Ribble Valley Borough Council  
Council Offices  
Church Walk,  
Clitheroe  
Lancashire  
BB7 2RA

Phone: 0300 123 6780  
Email: [developeras@lancashire.gov.uk](mailto:developeras@lancashire.gov.uk)  
Your ref: 3/2024/0934  
Our ref: 3/2024/0934/HDC/KW  
Date: 23 May 2025

**Location:** Canine Hydrotherapy Centre Howgill Farm Howgill Lane Rimington  
BB7 4EF  
**Proposal:** Regularisation of unauthorised vehicle access, car park, seating areas  
and siting of tea cabin.  
**Grid Ref:** 382795 446035

Drawing: Car Park and Access

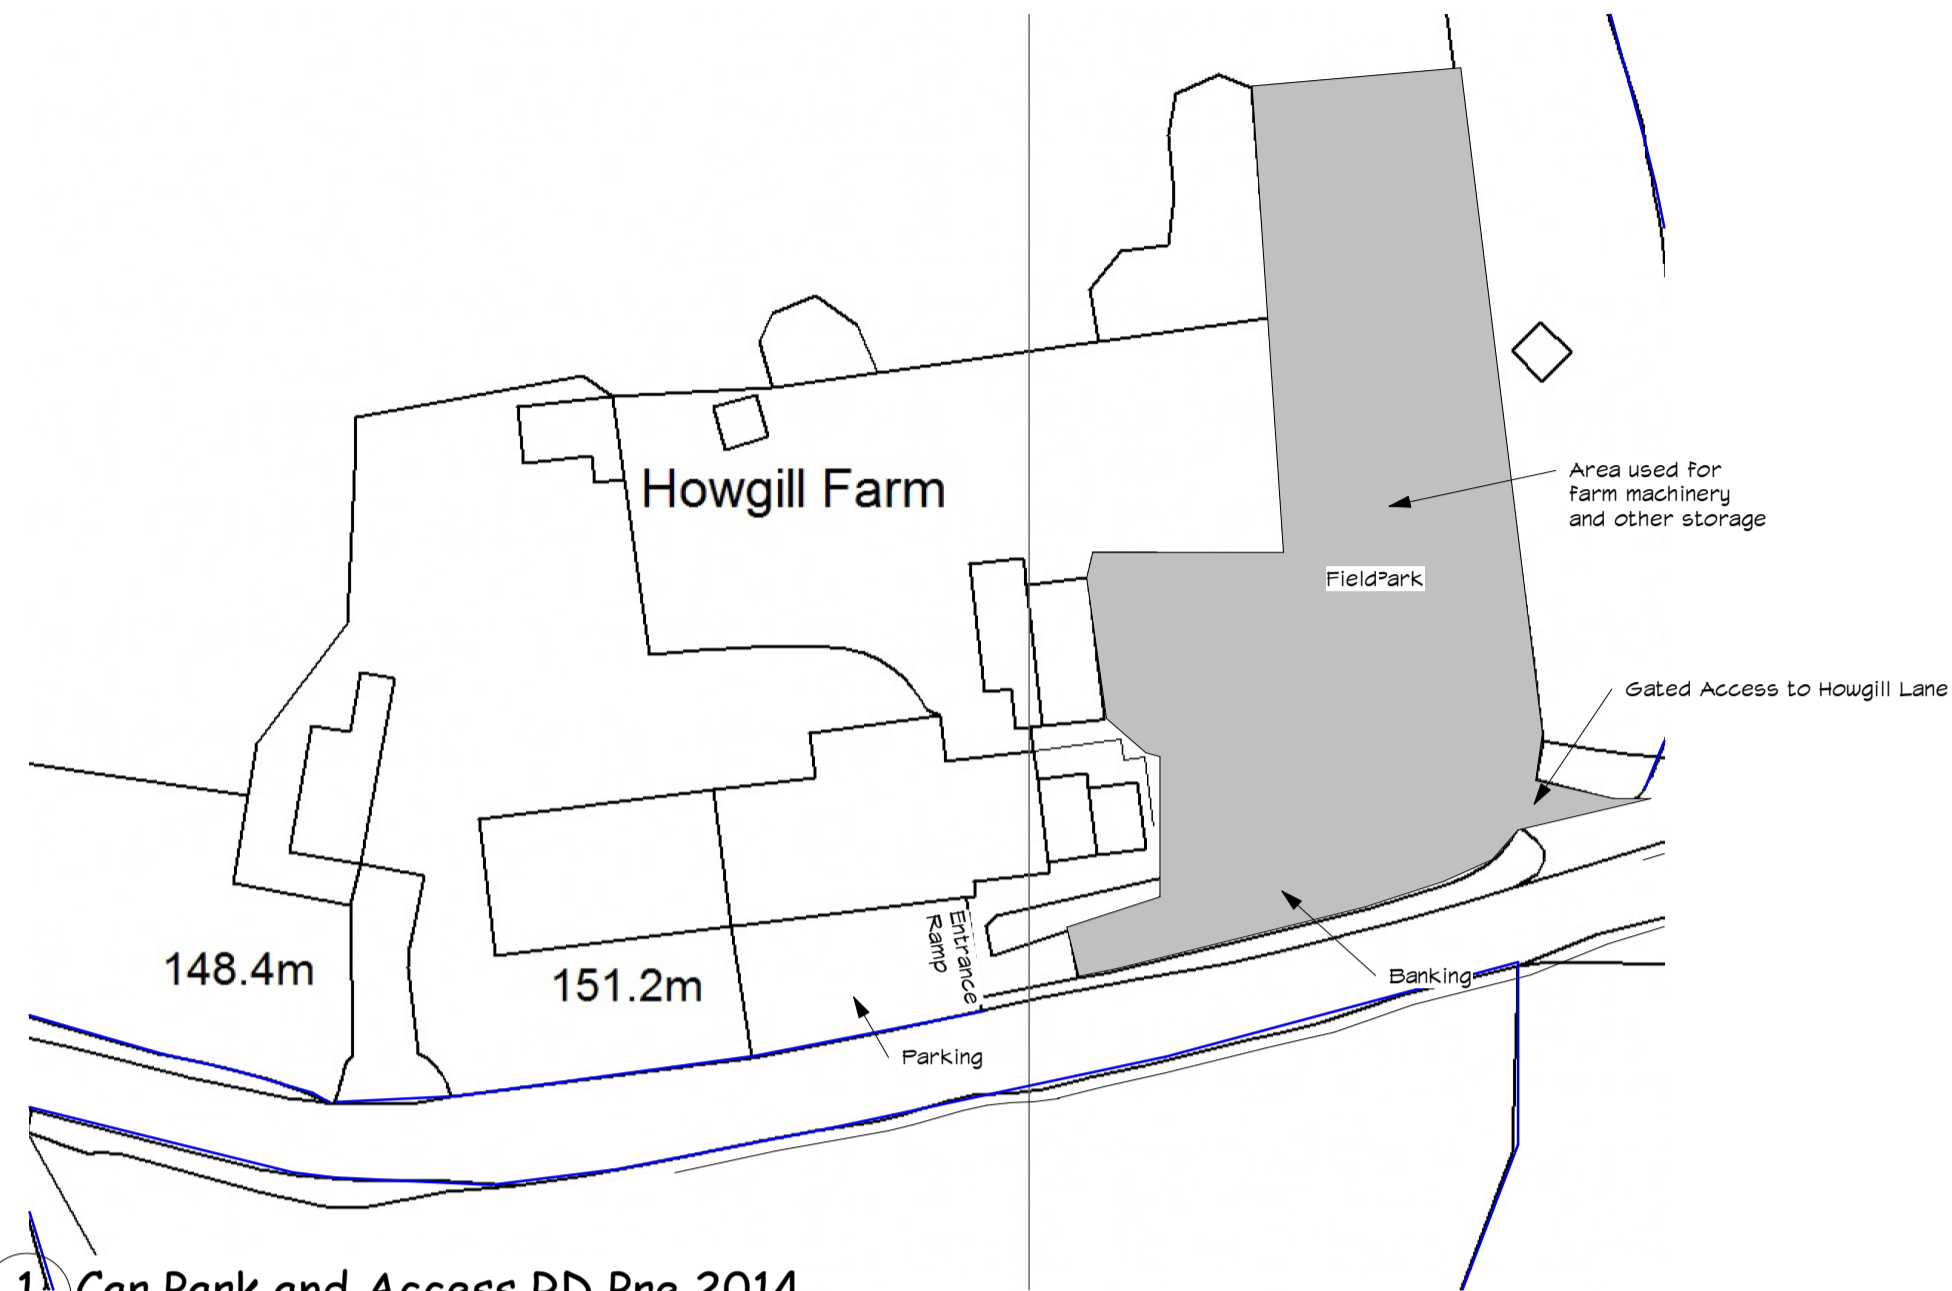
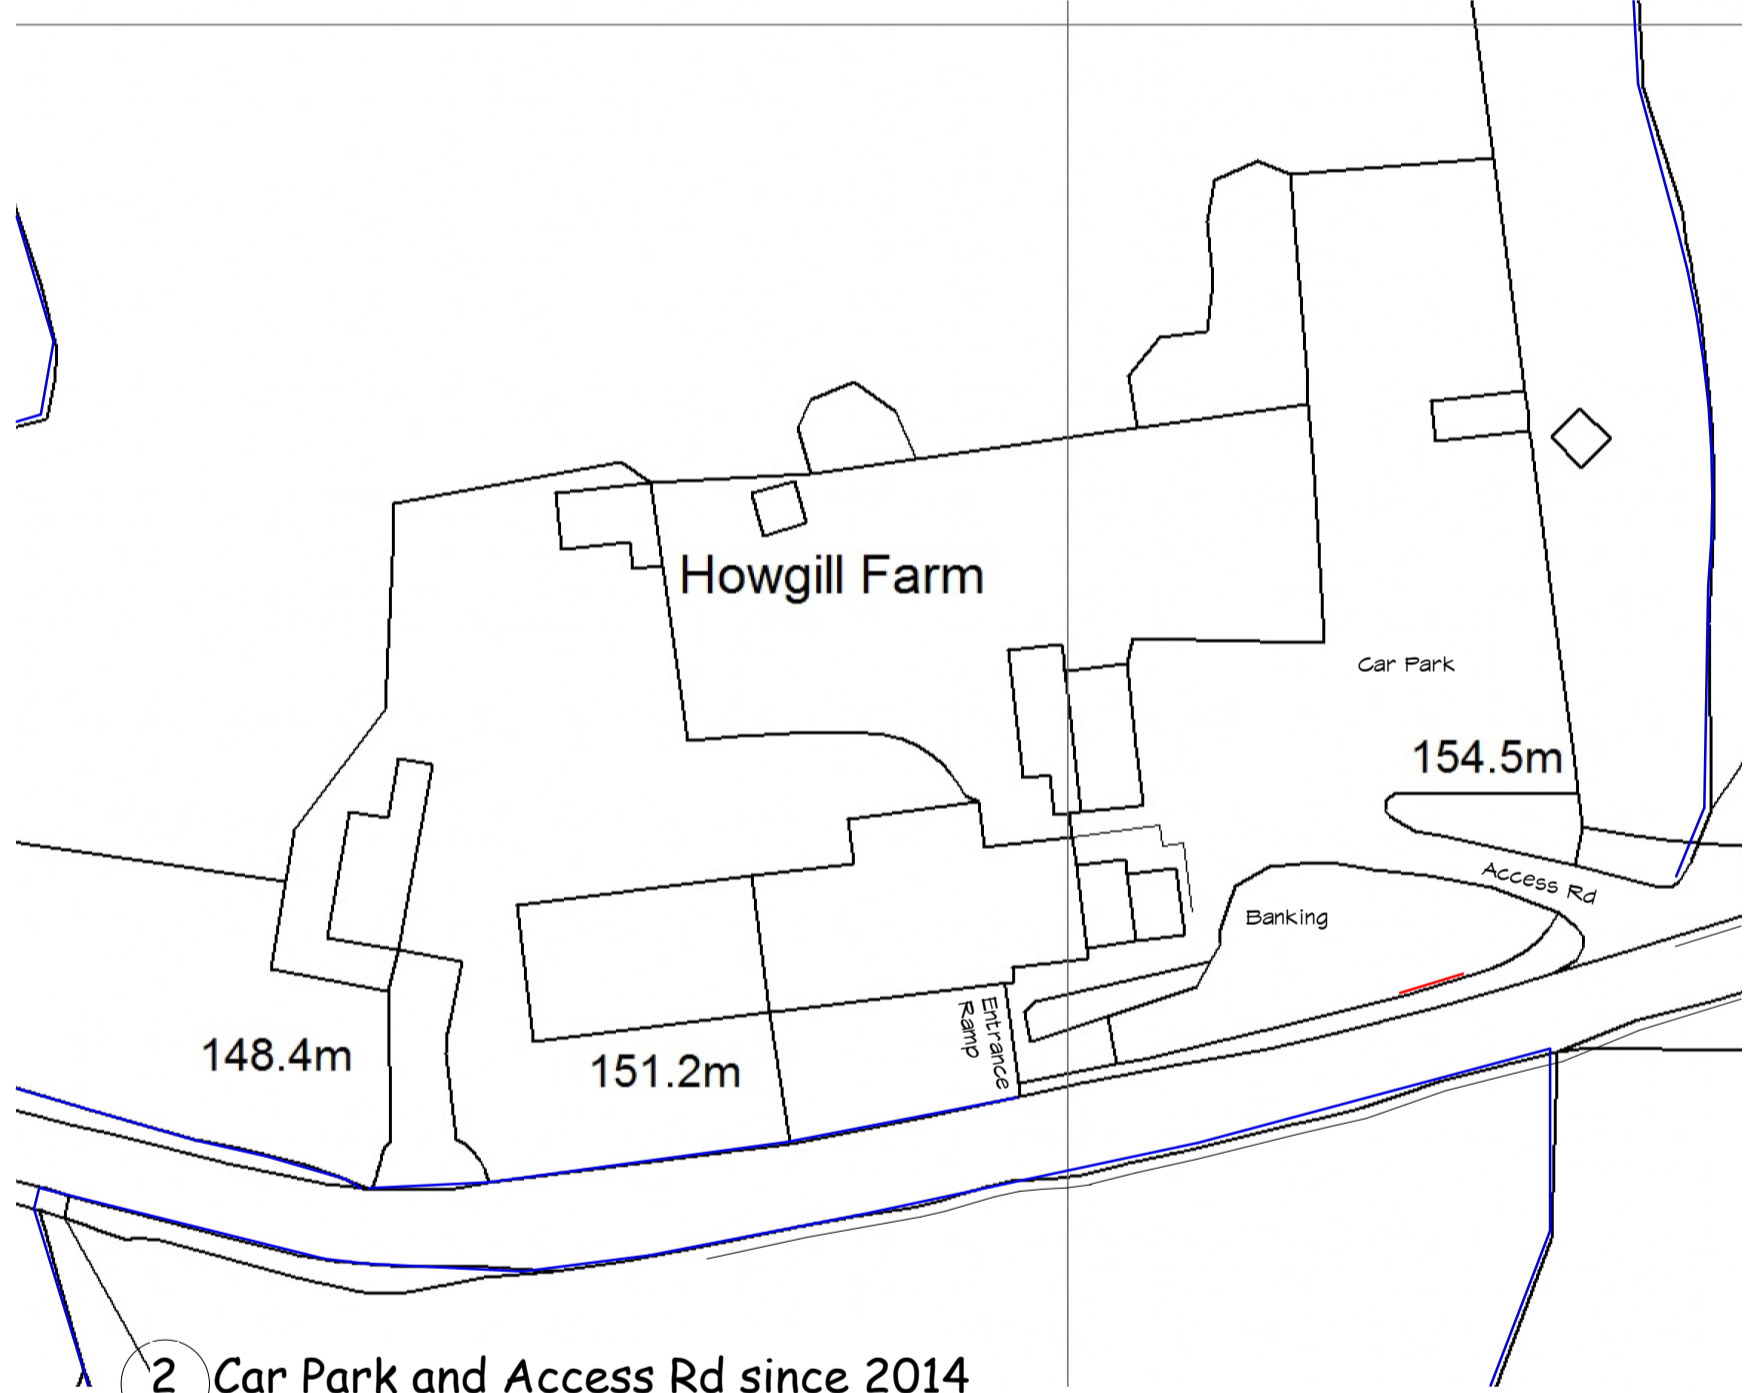
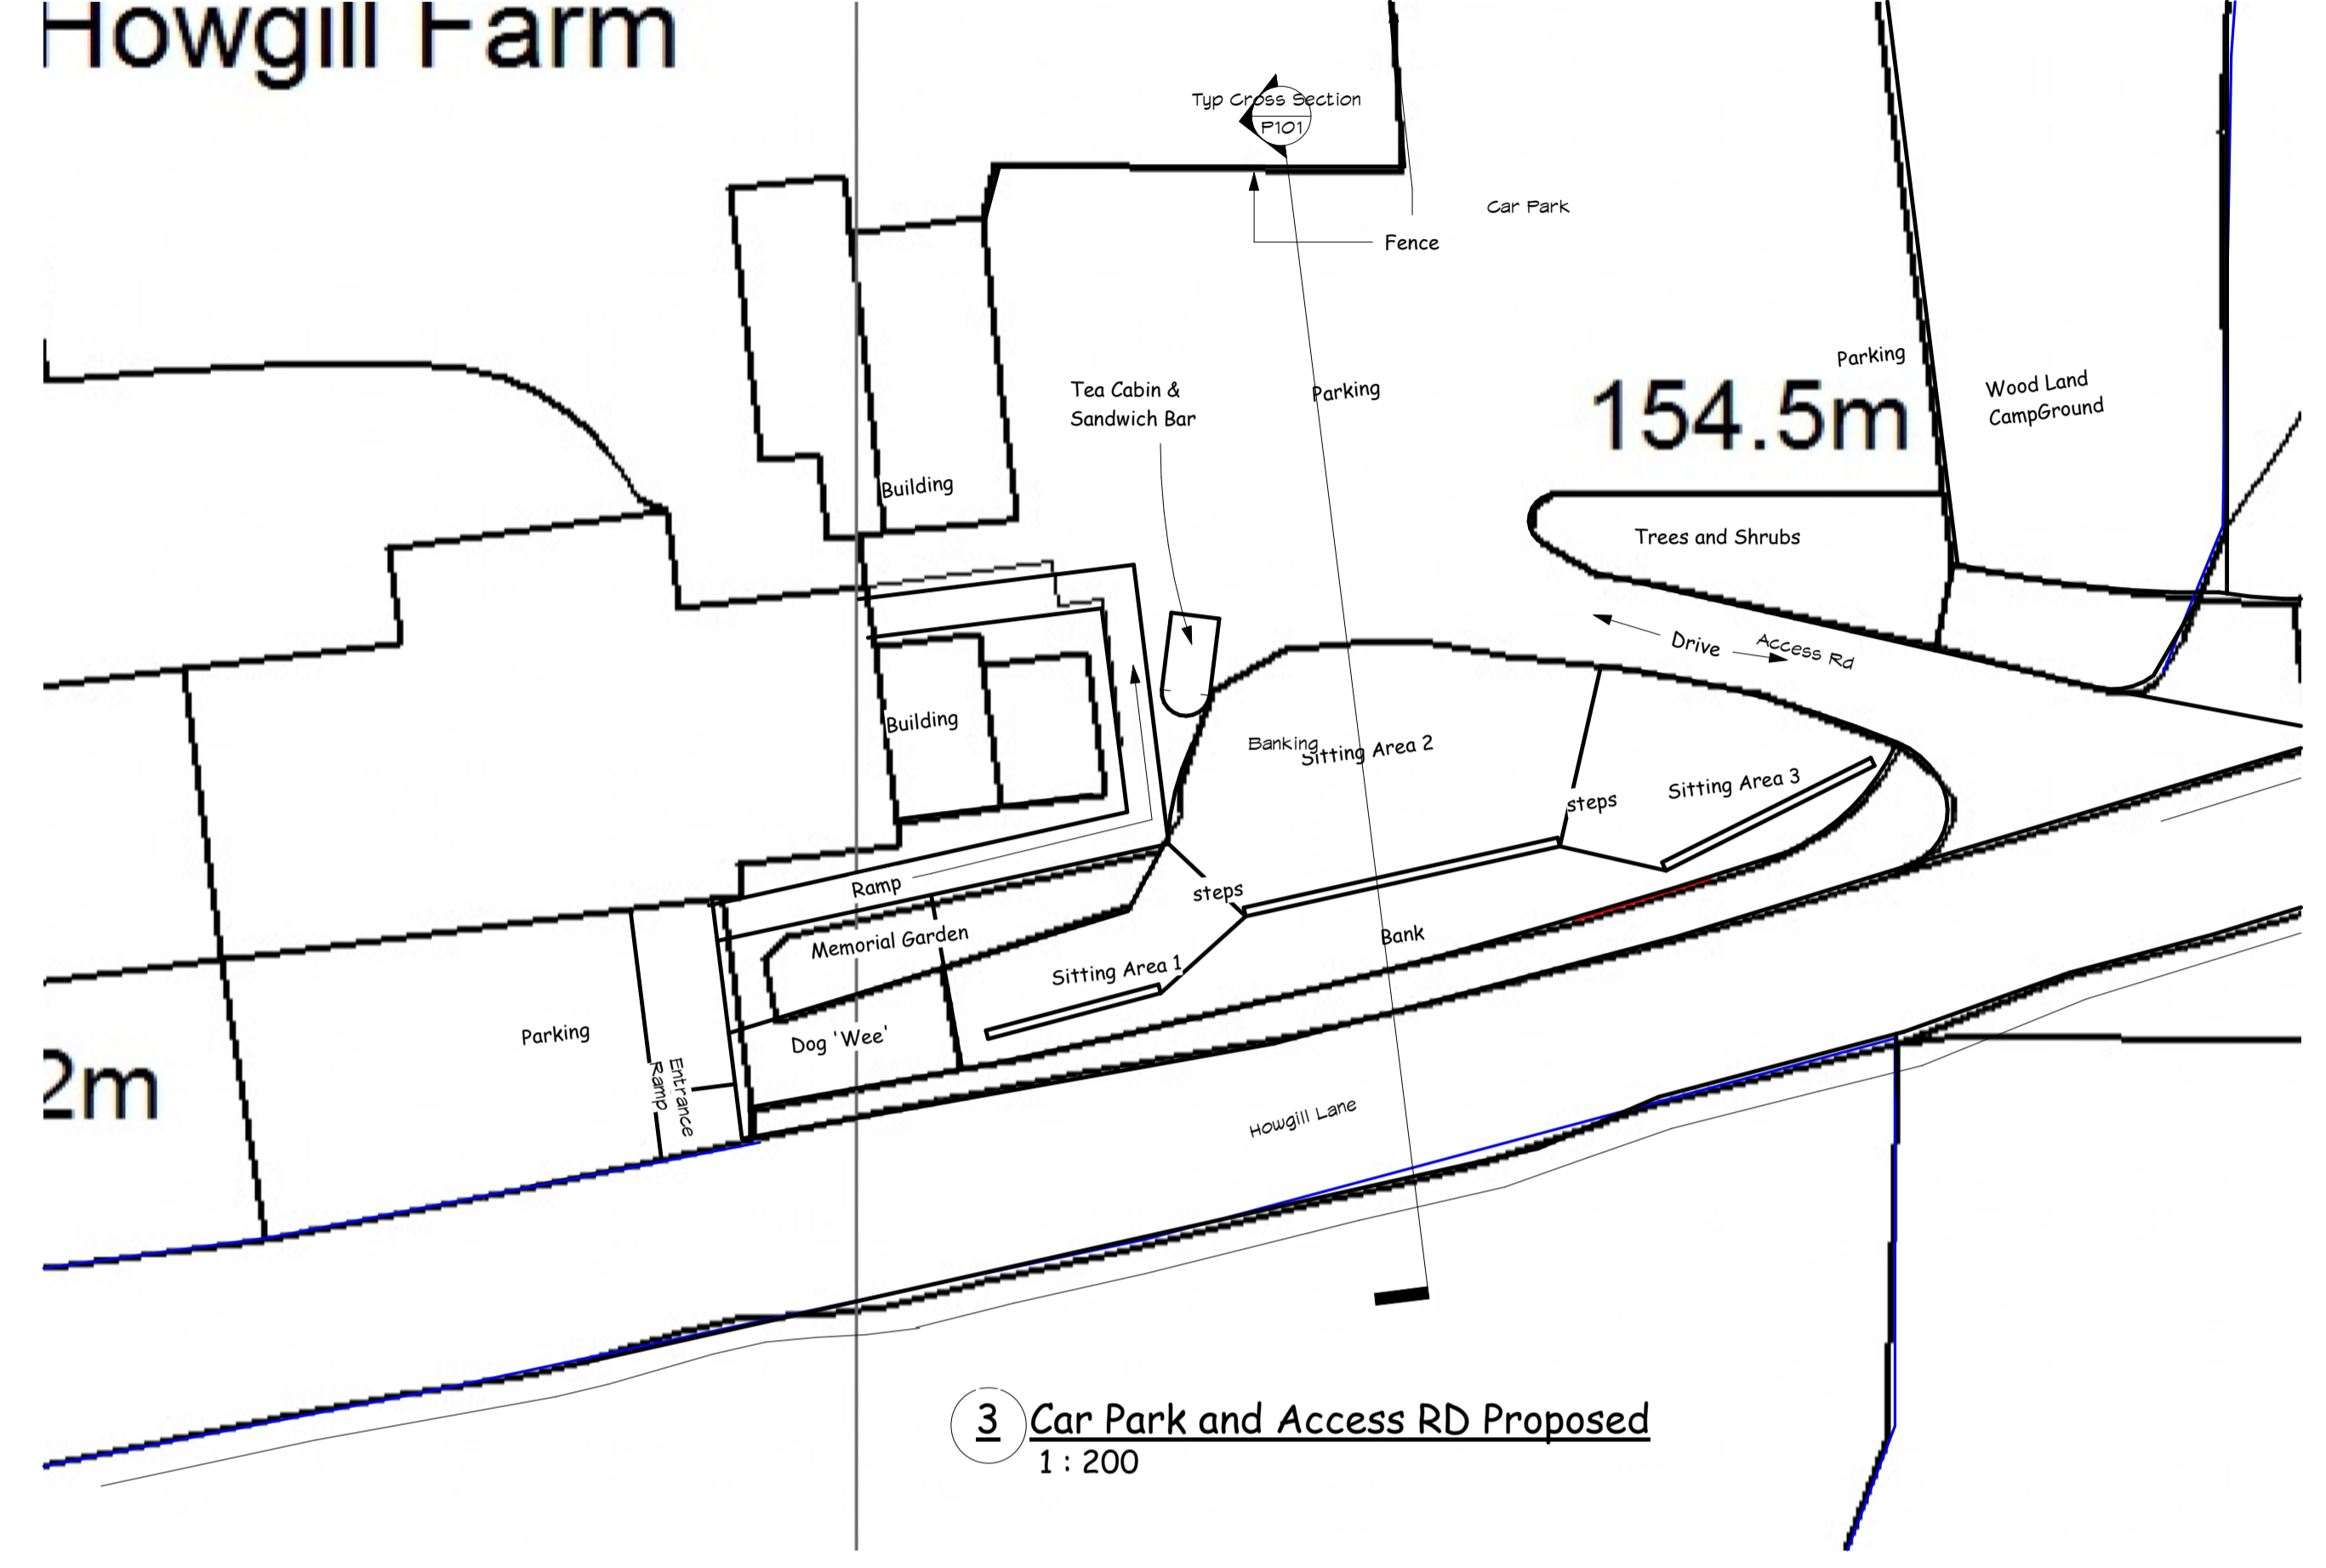
The access was originally a field gate and part of the access remains as such today as it continues to be shared with an adjacent field. The shared access opening is approximately 12m wide which reduces to approximately 2.7m as vehicles leave the highway and enter the site towards the car park. However, the Location Plan does not show the red line boundary joining the adopted highway which should be amended so as to include the entire access.

The access should be appropriately paved in a hard standing material, not loose stones or grass, for at least 10m into the site, to ensure that no debris is dragged onto the highway.

Further information is required regarding the operation of the business which may require access improvements such as widening to a minimum of 6m wide for at least 10m into the site to accommodate 2-way traffic and reduce the need for vehicles to wait within the highway.

A visibility splay should also be provided to ensure adequate intervisibility between highway users at the access. A visibility splay set 2 metres back from the near edge of the carriageway and extending at least 23 metres in both directions should be provided. Whilst this is not in line with the requirements for the speed limits, given the nature of the road, speeds are likely to be slower in proximity to the access.

The visibility splay should be wholly within the land which the applicant controls and/or the adopted highway and nothing shall be erected, retained, planted and / or allowed to grow at or above a height of 0.9 metres above the nearside carriageway level which would obstruct the visibility splay of the proposed access.

The applicant should provide accurate details of the required sight line requirement, before determining the application.

The proposal also includes a car park which was created in 2014 which provides additional parking provisions for the site and reduces the chance of on street parking in the area, according to the application form a total of 32 spaces can be provided although marked bays have not been provided on site or included within the site plans.

In conclusion, the Local Highway Authority require further information in order to assess the highway impact of the proposed development. A detailed site access plan should be provided, including the widths, surface material, and visibility splays. Additionally, clarification on the operation of the food and beverage cabin and the business operations, is necessary to enable the LHA to evaluate of highway impacts.
